KIRKLEES METROPOLITAN COUNCIL

UPDATE OF LIST OF PLANNING APPLICATIONS TO BE DECIDED BY STRATEGIC PLANNING COMMITTEE

Planning Application 2020/93358

Erection of 52 dwellings

HOUSE TYPE N - PLOTS 32,35,56 & 63
1914-HT-N-01
ABBAY ROAD, SHEPLEY
YORKSHIRE COUNTRY PROPERTIES
SCALE:1:100@A3 - AUG 2020

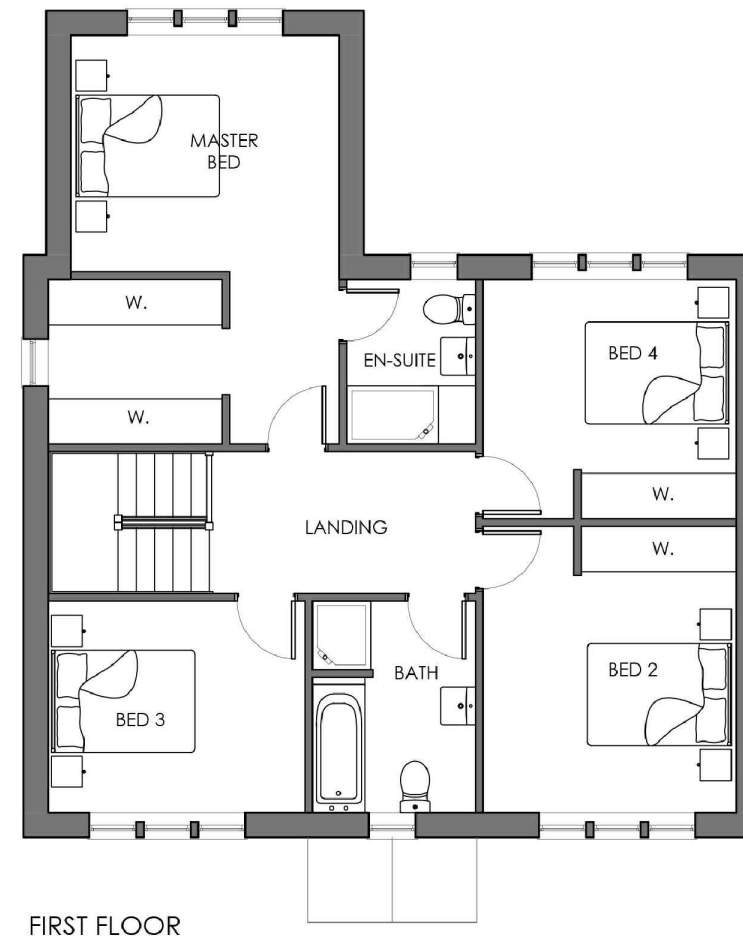
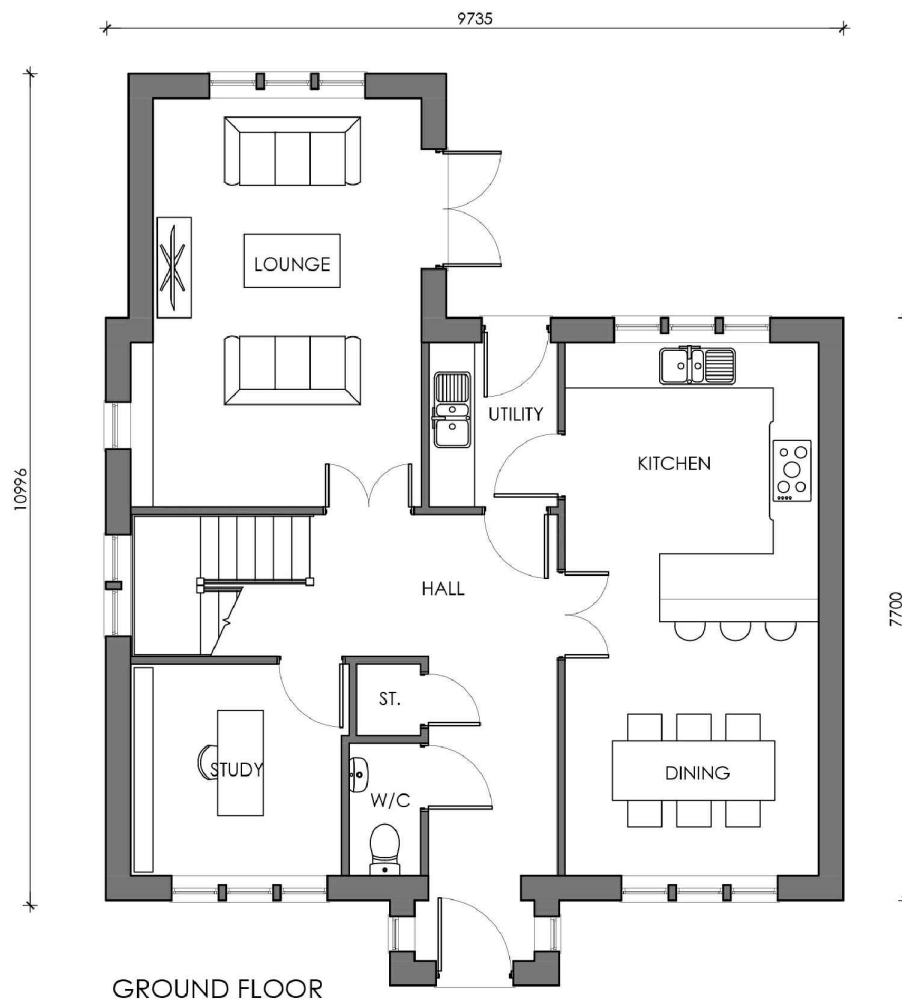
The applicant has also amended the site layout plan with substituted detached dwelling houses found at plots 32, 35, 57, 58, 60 and 65. The number of units on the site is unchanged but two 4 bed units are changing to 3-bed units. The mix is acceptable. All of the units would still exceed Nationally Described Space Standards.

REFUSE TRACKING PLAN - PHASE 2 PROPOSALS - ABBEY ROAD, SHEPLEY

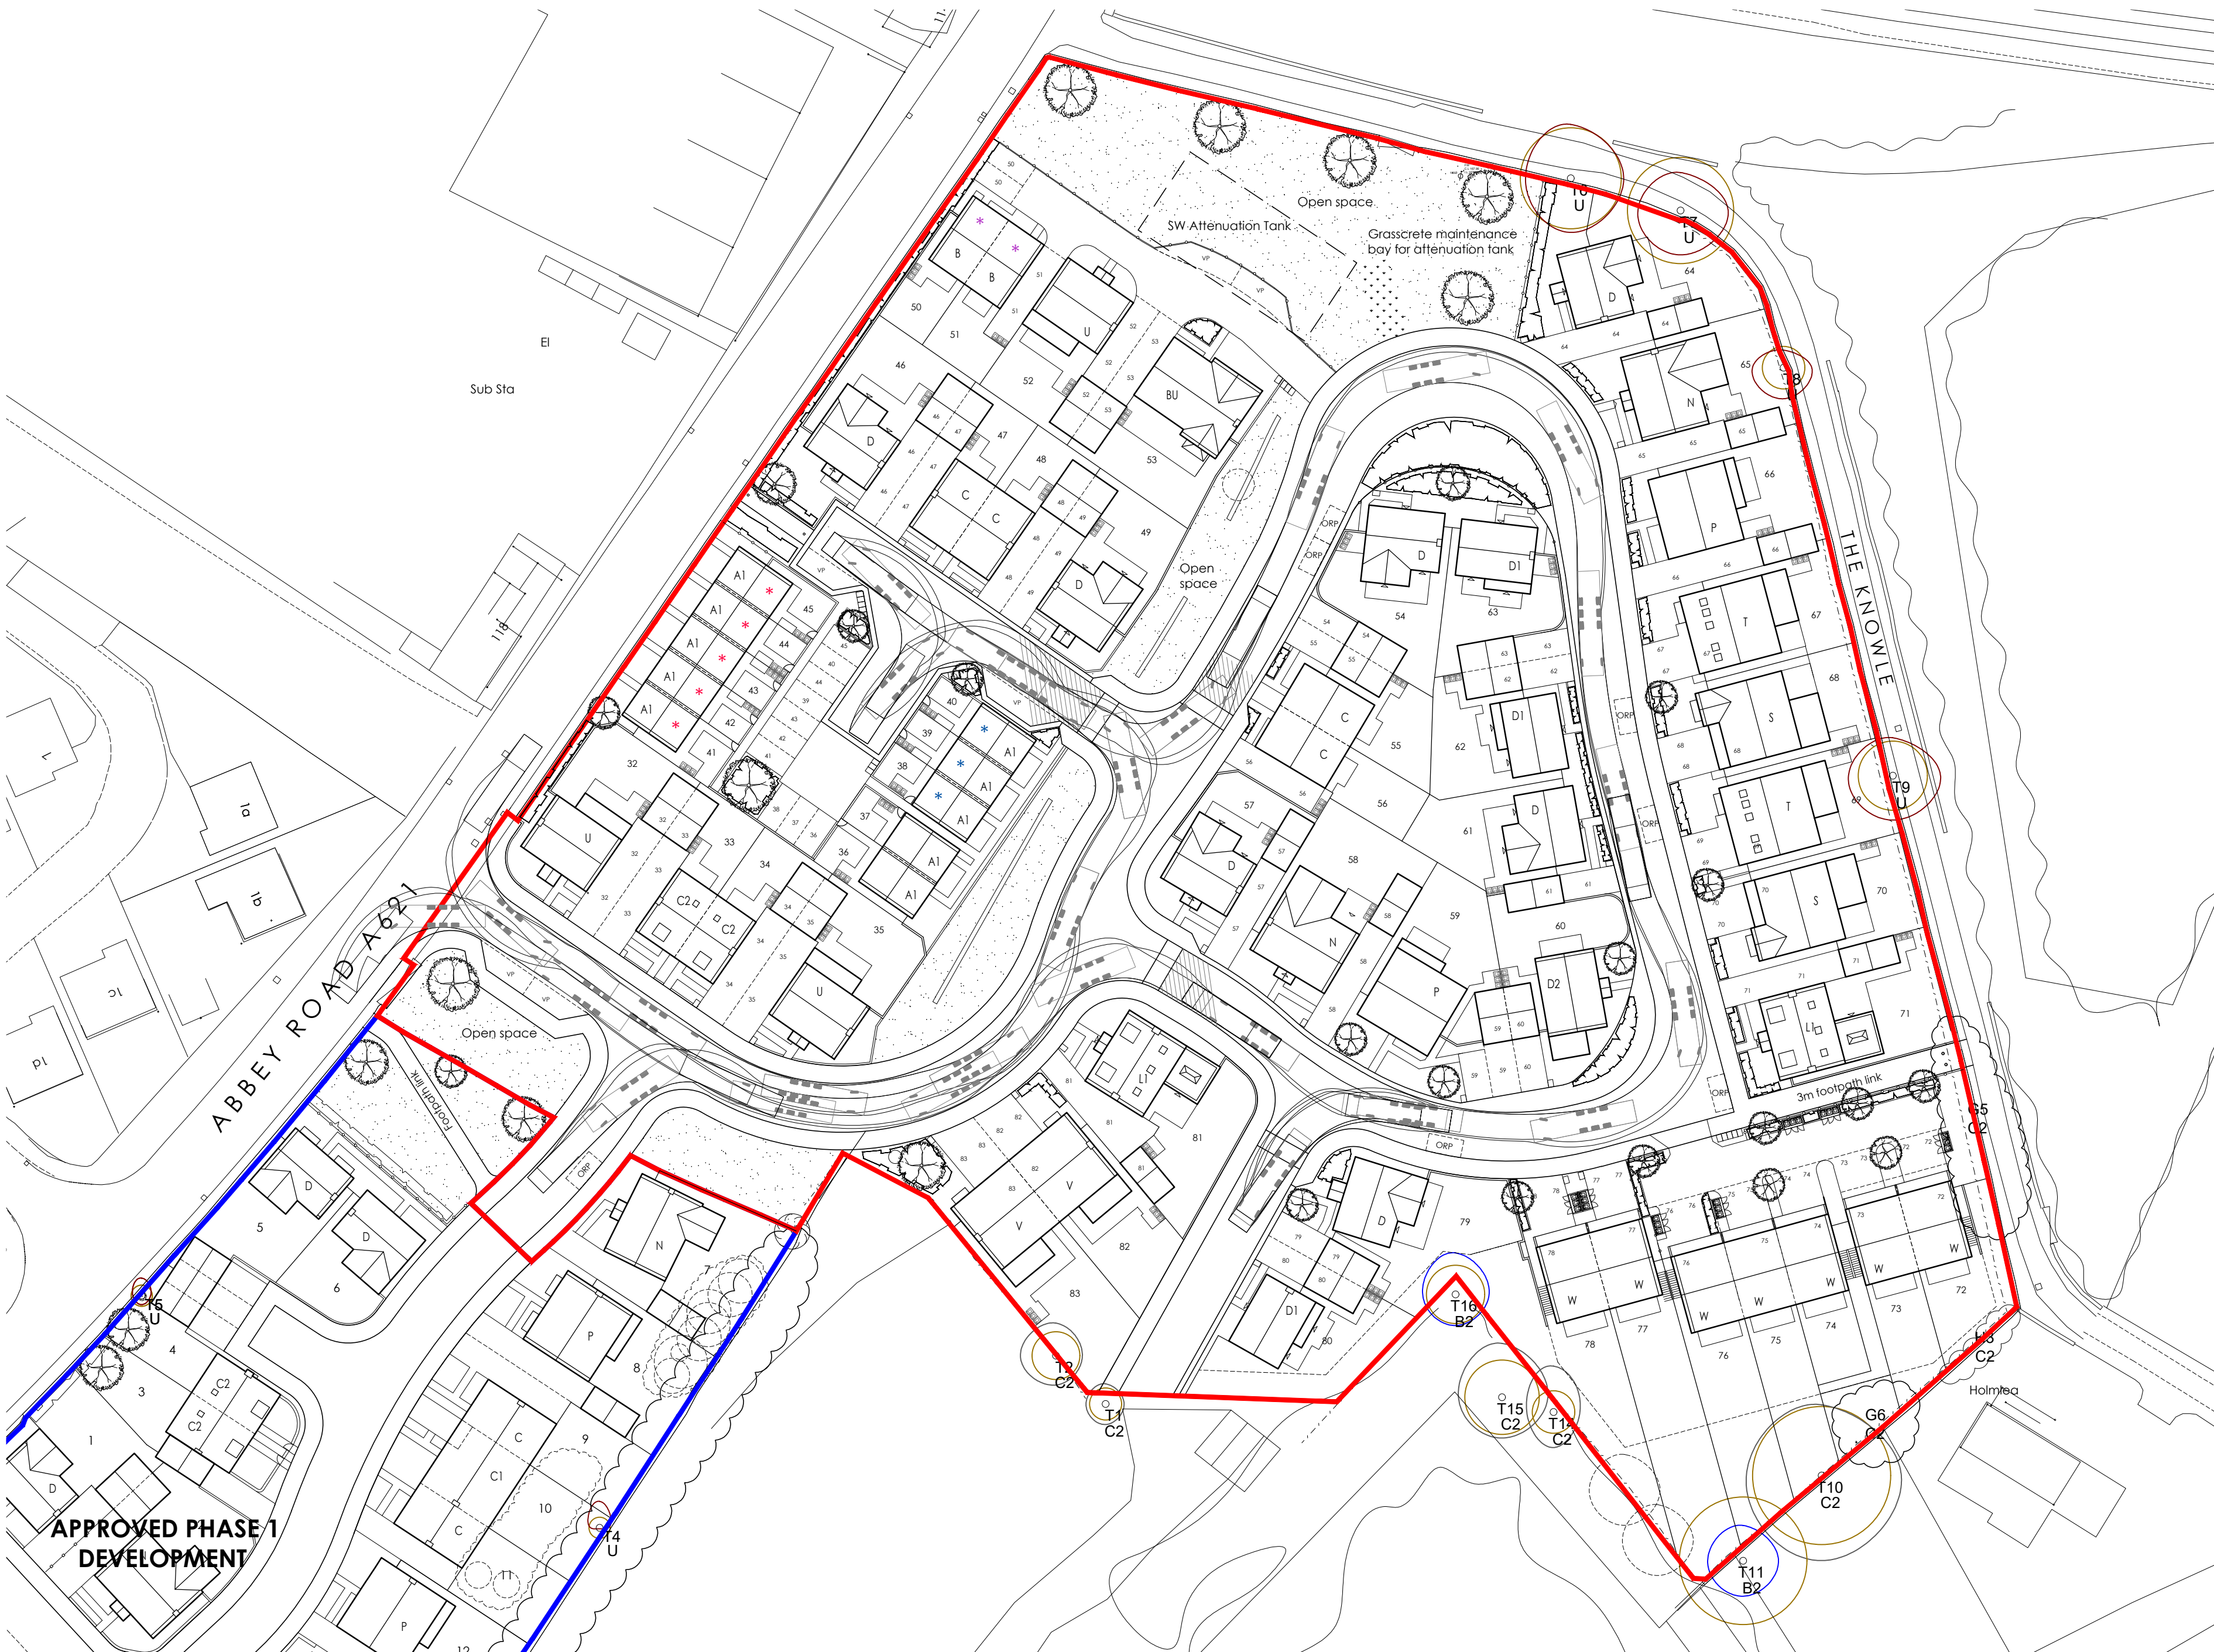
- Planning Layout – Phase 2, Reference: 1914-SI-22G, Dated: September 2020
- Masterplan / Phase 2 Proposals, Reference: 1914-MP-01K, Dated: January 2020
- Refuse Tracking Plan – Phase 2, Reference: 1914-SI-25D, Dated: February 2021
- Enclosure Plan – Phase 2, Reference: 1914-SI-23D, Dated: September 2020
- Open Space Plan, Reference: 1914-MP-26E, Dated: August 2020
- House Type Booklet, Reference: 1914-HT-02 Revision B, Dated September 2020
- Phase 1 & 2 Composite Layout, Reference: 1914-MP-01K, Dated: January 2020
- Planning Layout – Phase 2, Reference: 1914-SI-22G, Dated: September 2020
- Schedule of Accommodation

Officer response: The changes have been made primarily in response to discussions with Highways Development Management and Highways Section 38. The main changes include the provision of visitor parking spaces, with 2 off-road spaces now opposite plot 32 (with a change in public open space from of 236sqm - 202sqm) and one off-road space opposite plot 45; the estate road has been slightly widened with improved forward visibility at plot 60; and a 3m wide footpath link to the Knowle that connects across the grass verge.

Highways Development Management: I have reviewed the revised plan; Planning Layout Phase 2 - Drawing No. 1914-SI-22G, Rev.G, which I can confirm satisfactorily addresses outstanding highways issues regarding the footway link to The Knowle and forward visibility on the bend adjacent to plot 60. The layout is considered acceptable and suitable for adoption.
